Comments for Planning Application 22/2198/CON

Application Number: 22/2198/CON

Address: 4 Nesbitts Alley Barnet EN5 5XG

Proposal: Submission of details of condition 5 (Refuse and recycling store) 6 (Cycle parking) pursuant to planning permission 21/1453/FUL dated 14/03/22

CONDITION 5 AND 6
21/1453/FUL

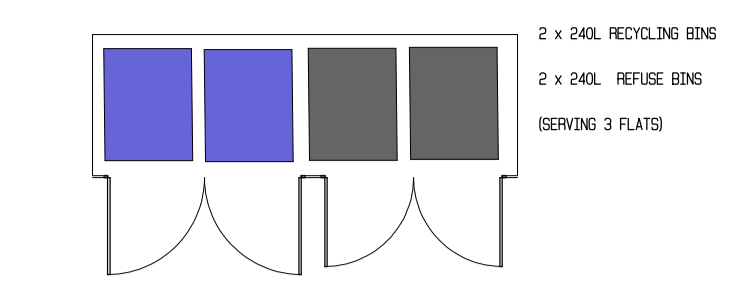
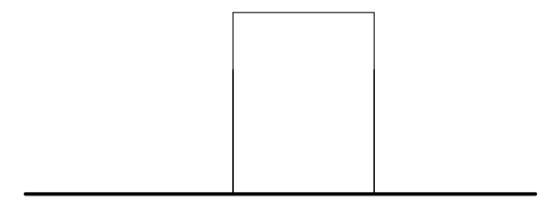
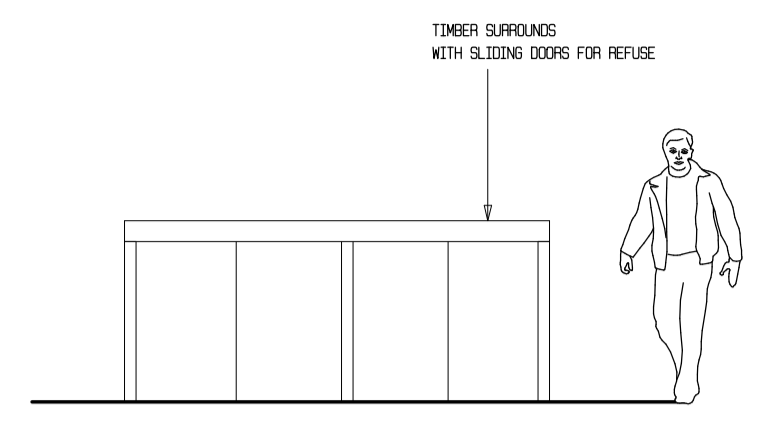
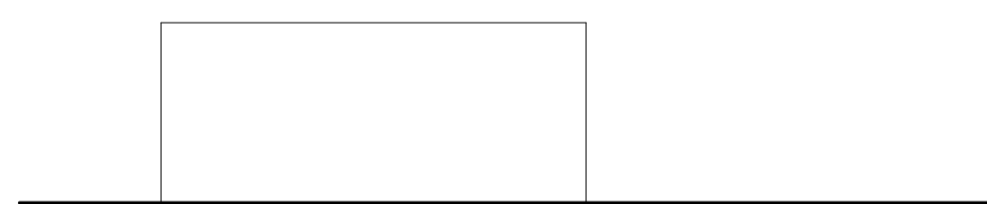
Comment: No details regarding what the boundary between 4 & 6 Nesbitts Alley shown, what is being proposed? The current location of the bins and bike rack will significantly block our light to the lower floor unit of No. 6 Nesbitts Alley.

Cycle rack is very tall (taller than a boundary fence) with no accurate dimensions shown. How will it drain, it appear to drain onto our land.

Drawing shows 4 Nesbitts Alley as 6a, this is incorrect.

The cycle store and bins, located centrally in the courtyard will greatly impact on the front elevation of 6/6a Nesbitts Alley. We suggest that if one is required it should either be a low profile option or preferably against no. 4 Nesbitts Alley elevation. We strongly object to this proposal and would want to see a daylight study undertaken to justify its location.
